DECISION DELEGATED TO DEVELOPMENT MANAGER

Application No: H12-0190-20 **Applicant:** Mr & Mrs S Laker
Proposal: Extension and Alterations
Location: Oakwood Marriots Gate Luton
Terminal Date: 27th July 2020

FLOOR PLANS & ELEVATIONS - PROPOSED
SITE PLANS.

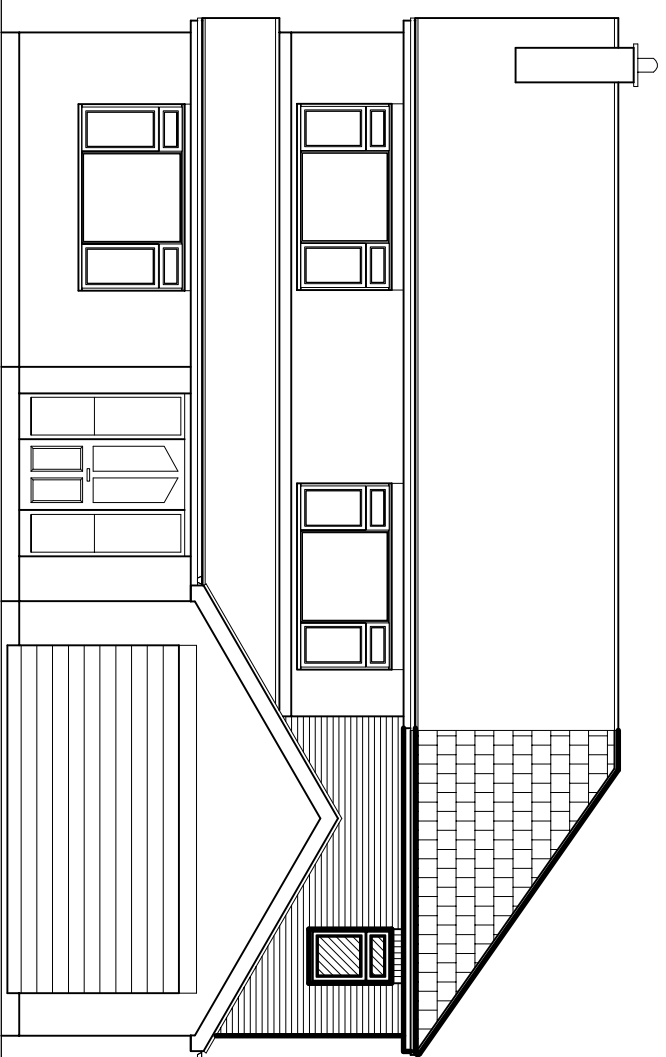
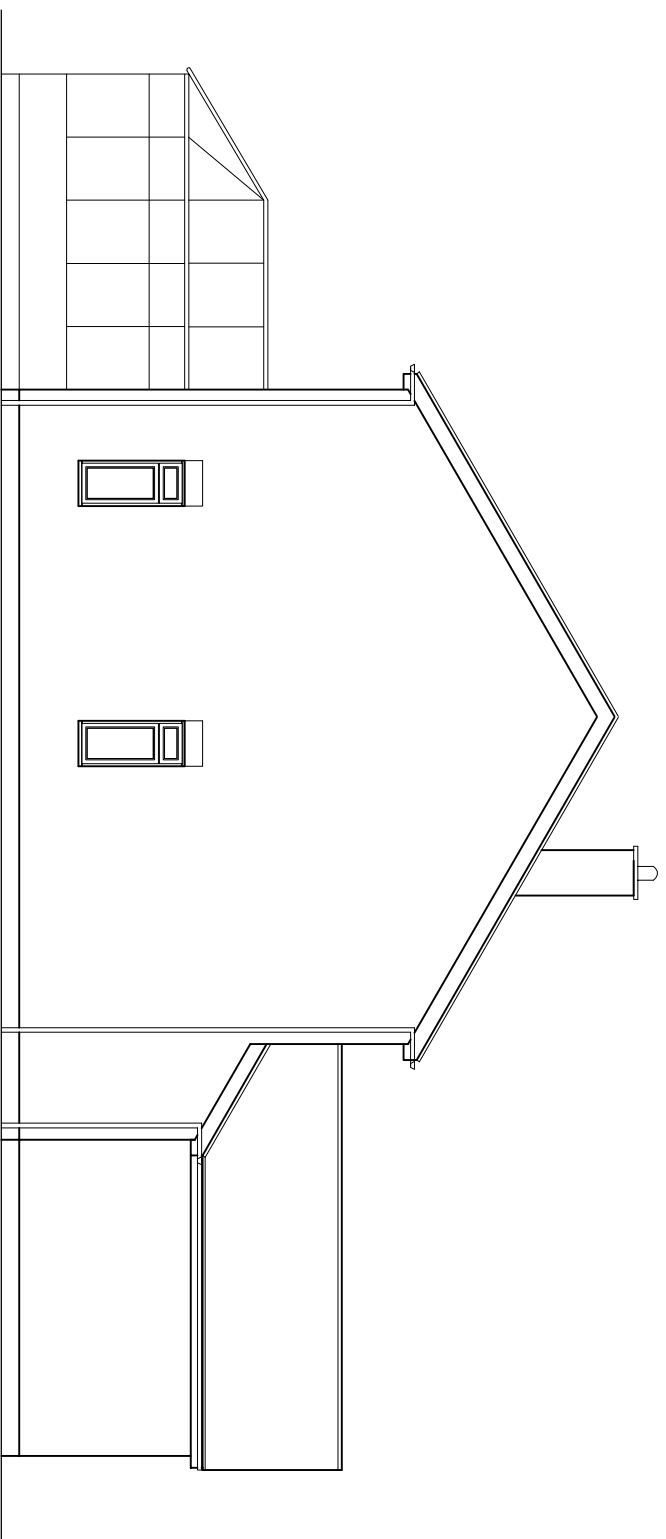
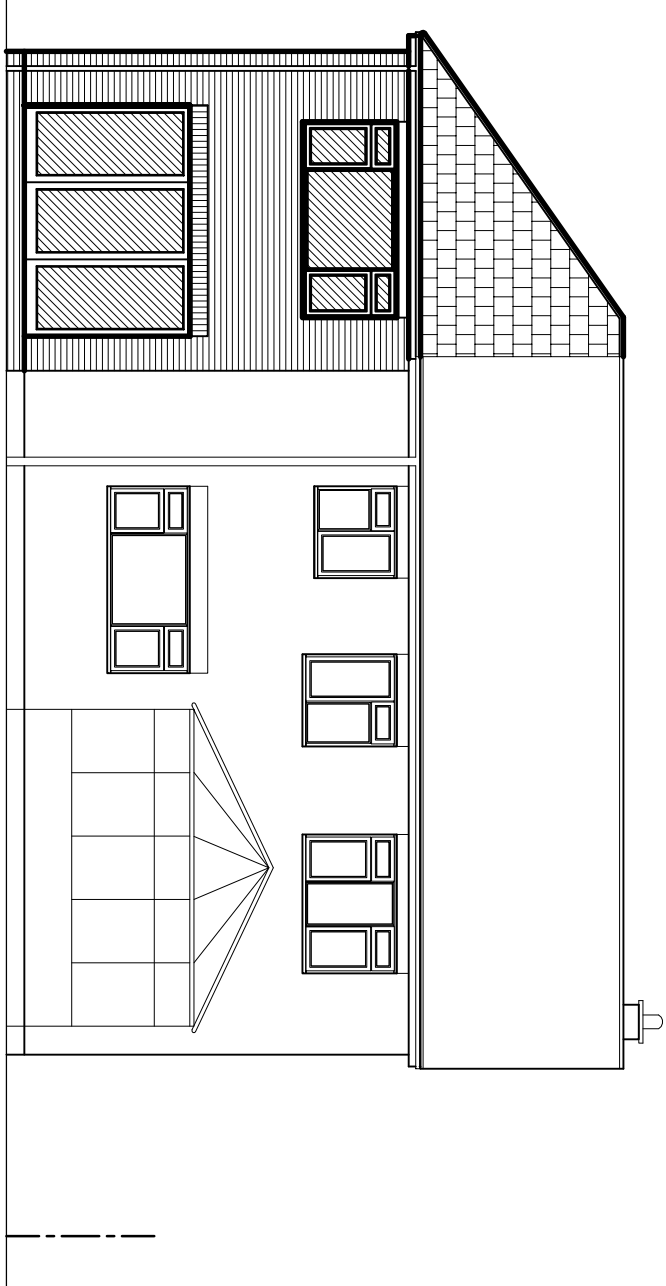
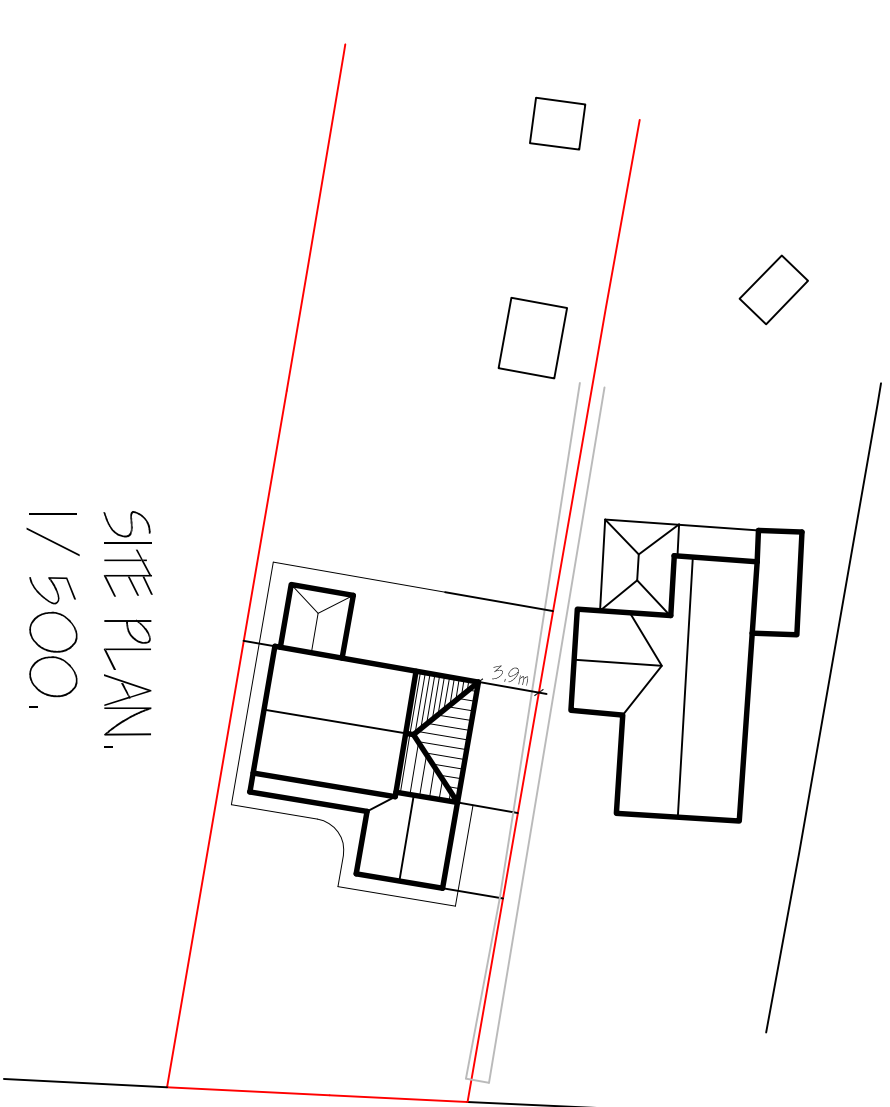
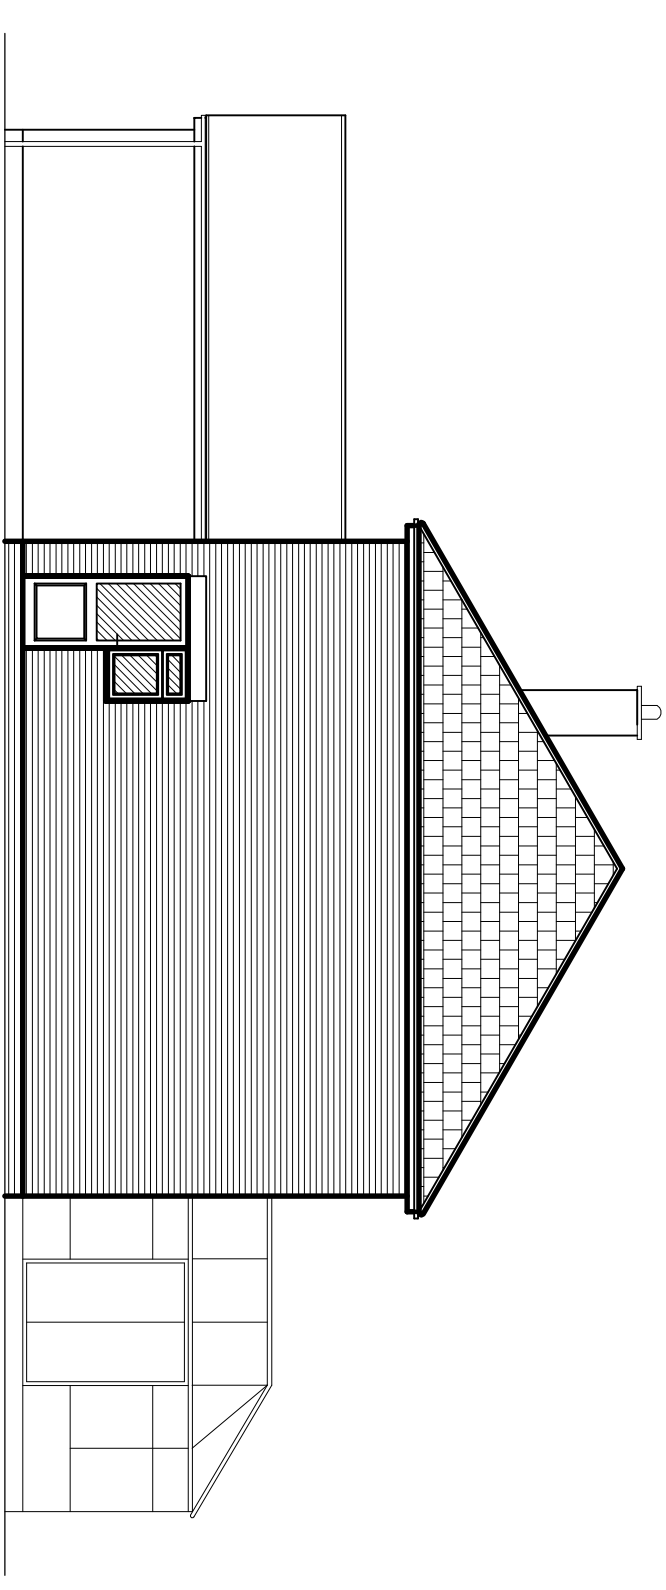
The initial proposal was gable pitched, in keeping with the main roof of the house. In light of a public objection and case officer concerns, revised plans were submitted proposing a hip roof in order to comply with BRE 25 degree rule from the windows in the opposing elevation and overall ensure acceptable amenity standards to the adjacent residents.

The initial plans were proposing a gable pitch roof on top of the extension in keeping with the main roof of the house. In light of one resident objection and case officer concerns regarding the potential for overshadowing, revised plans were submitted proposing a hip roof instead in order to comply with BRE '25 degree rule' from the centre of two windows for habitable rooms on the opposing elevation.
